AT&T SITE NAME:
SCHREIWER AFB

AT&T SITE NUMBER:
COL02065

SHEET DESCRIPTION:
PARCEL PLAN

SHEET NUMBER:
P-1

SHEET NUMBER:
P-1

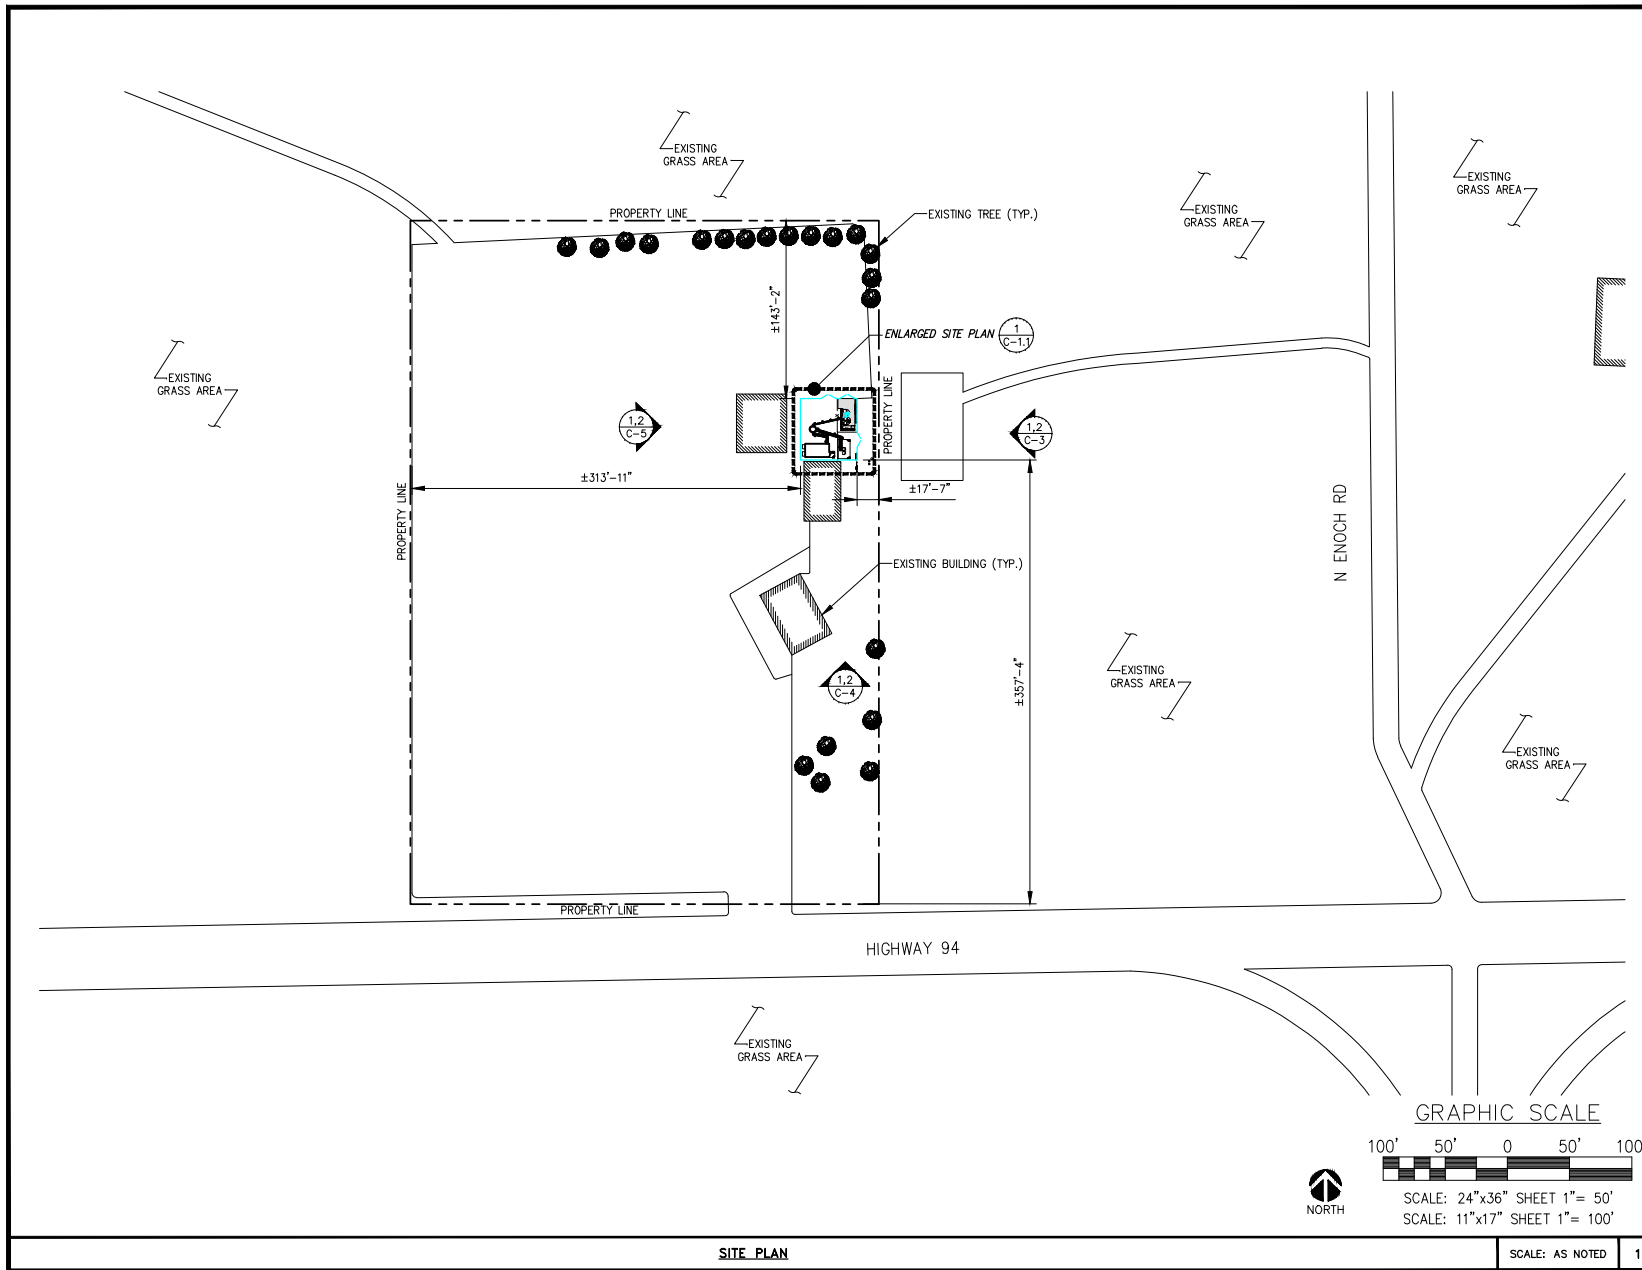
Add PCD File #

Add correct address on each page - 15640
 Highway 94 per enumerations comment
